**Consultation Response from KC,
Lead Local Flood Authority**

2025/92161 Land adj, 17, Whitehall Road West, Birkenshaw, BD11 2LS

Discharge of details reserved by conditions 4-8 (intrusive investigations), 11 (Remediation Strategy and Verification Report), 12 (CEMP), 13 (noise), 14 (Arboricultural Method Statement), 15 (CMP), 16 (highway), 17 (visibility), 18 (Safety Audit), 19 (estate streets), 20 (waste collection), 21 (surface water attenuation), 24 (bin storage), 25 (bicycle storage), 26 (drainage), 28 (drainage), 29 (CEMP: Biodiversity),-30 (landscape), 34 (solar panel array), 35 (materials), 38 (boundary treatments) on previous permission 2024/92281 for erection of 23 dwellings

Date Responded: 1st March 2026

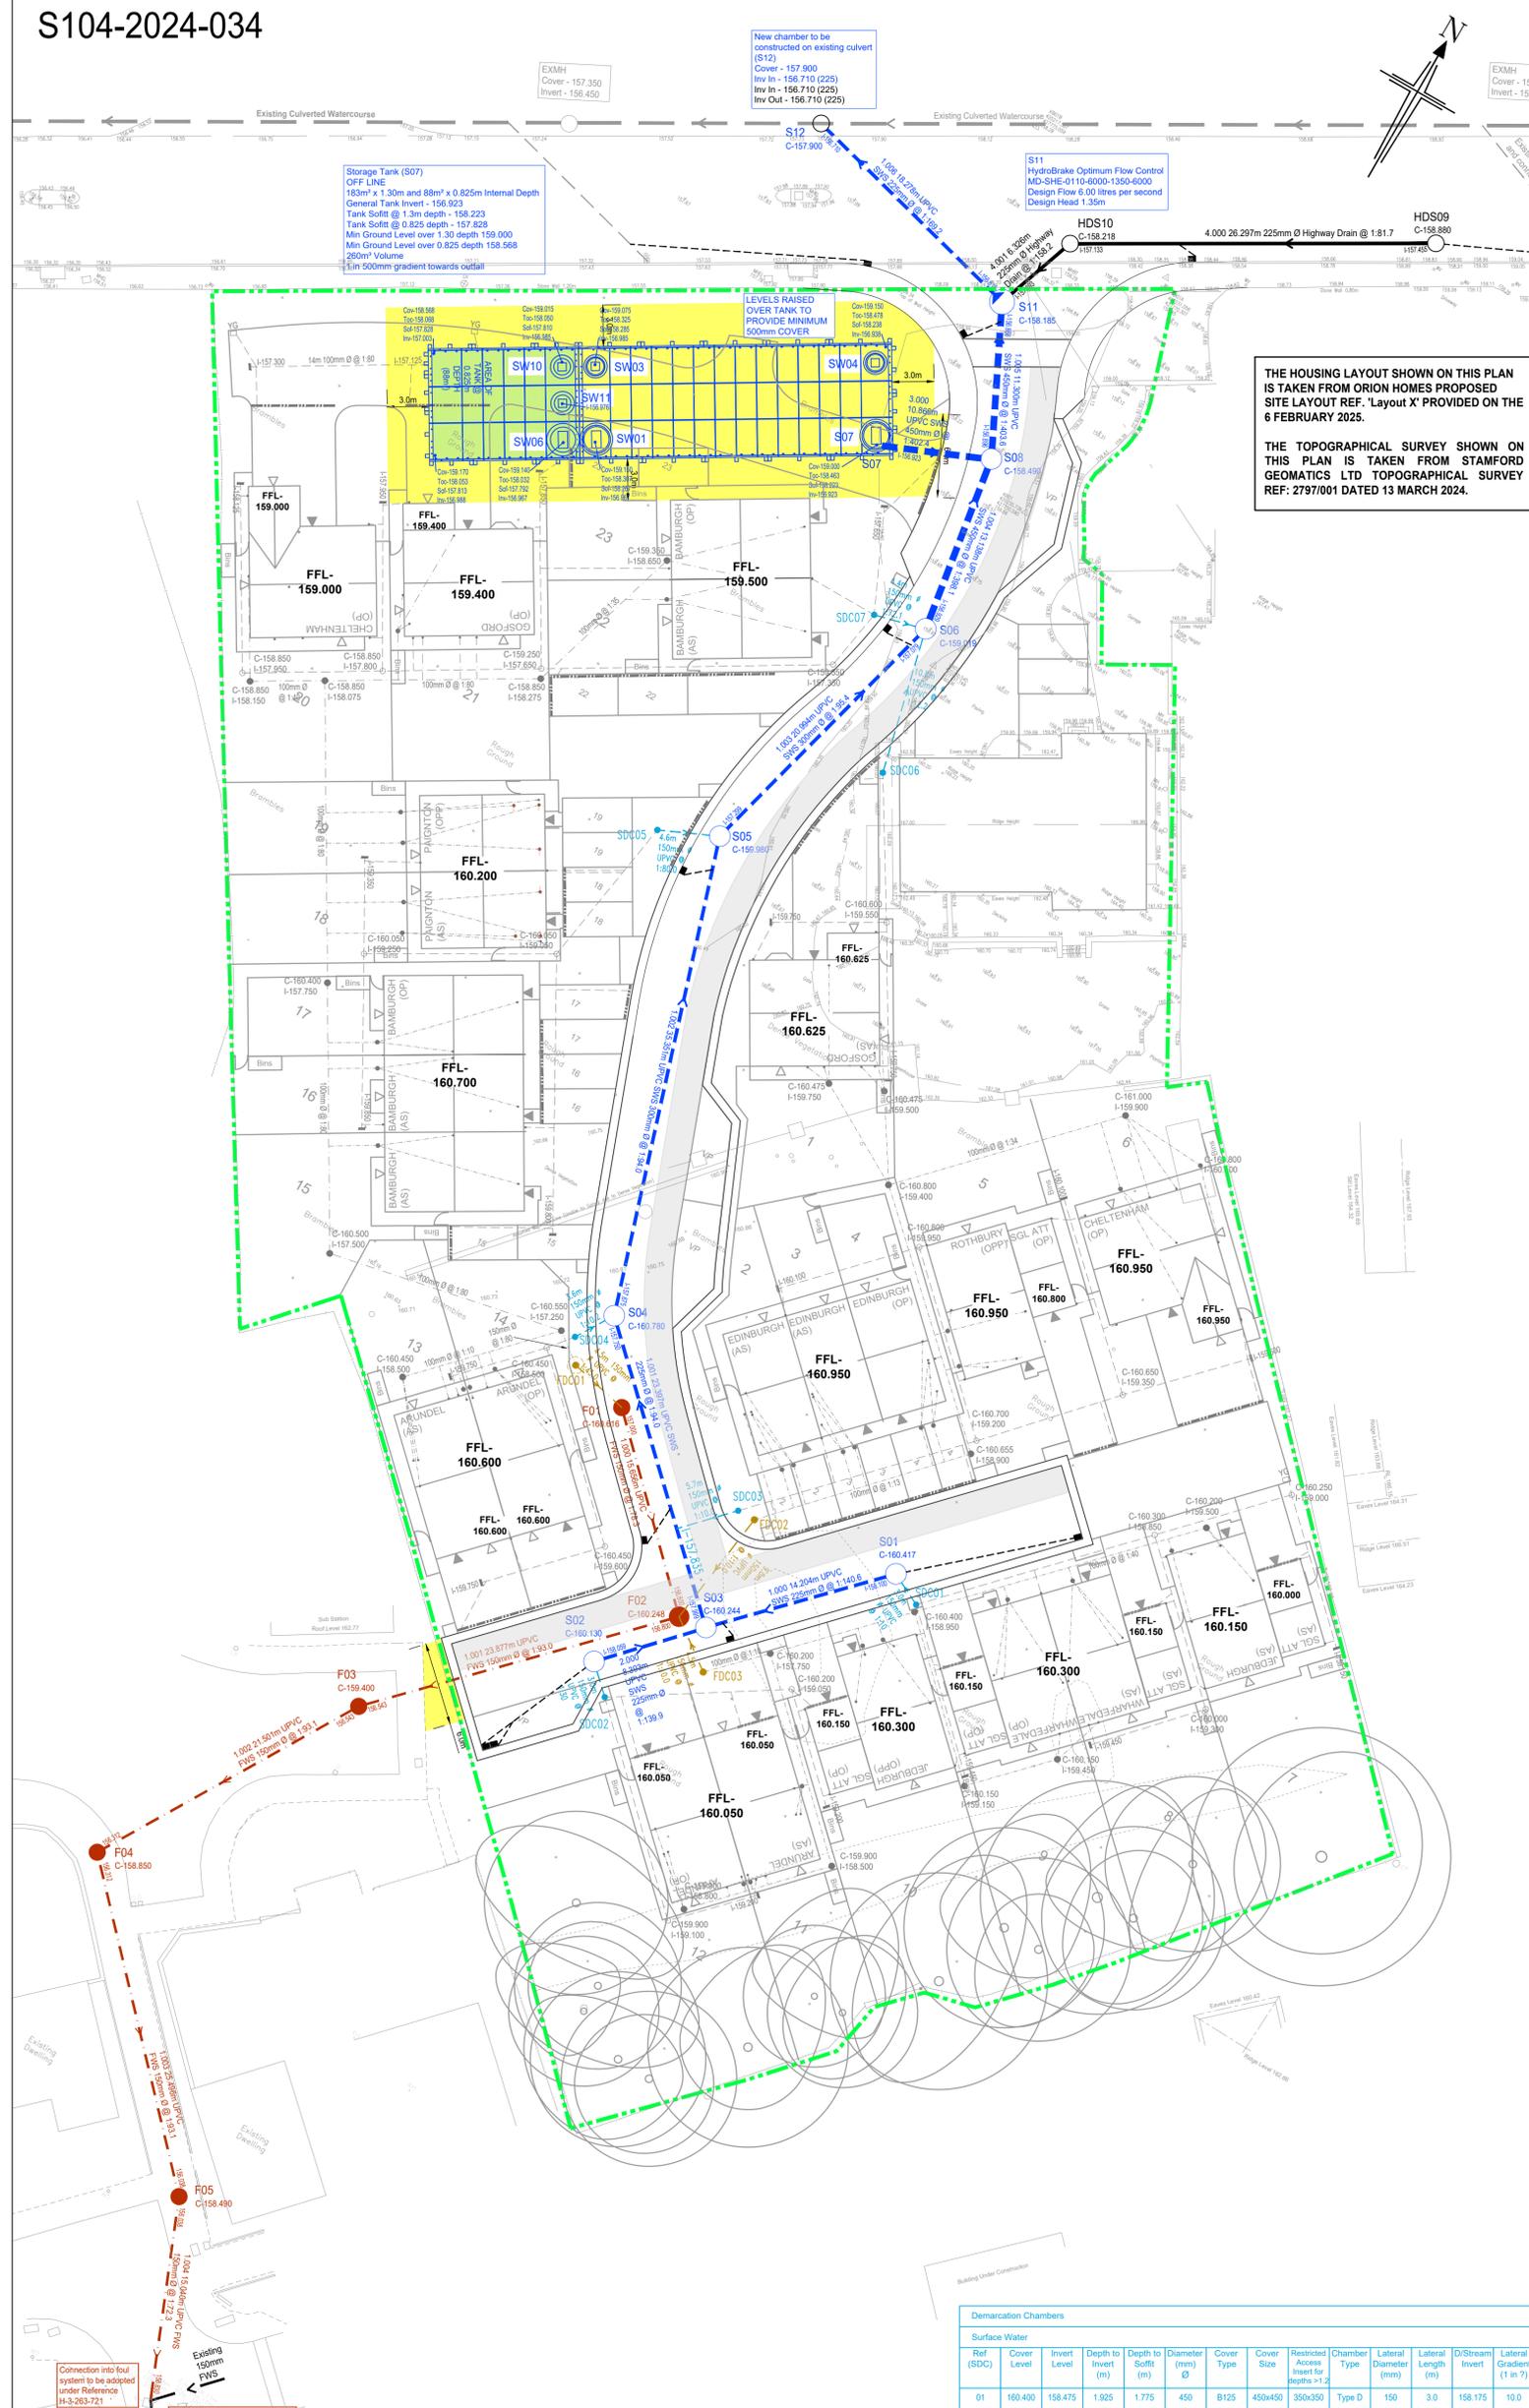
A more detailed maintenance plan has been provided. Although many of the aspects are generic, the LLFA will accept these, i.e. gullies and manholes.

The flow control device should have a replacement of the neoprene seal if the flow control must be removed for blockages at any point in the future.

For the attenuation tank, we would expect a more bespoke plan. However, we understand for the initial application that an FP McCann, concrete tank was to be used that can easily be accessed by camera for inspections. We can't comment on the design for man entry, this is a matter for the principal designer who oversees CDM regs 2015 and ensures a maintenance plan is provided before handover.

We advise the planning officer that confirmation is required that the design for the tank is FP McCann with submitted drawings, and has not been changed to crate storage which cannot be maintained as described in the report. Once this is done the condition CAN be discharged without further consultation to the LLFA
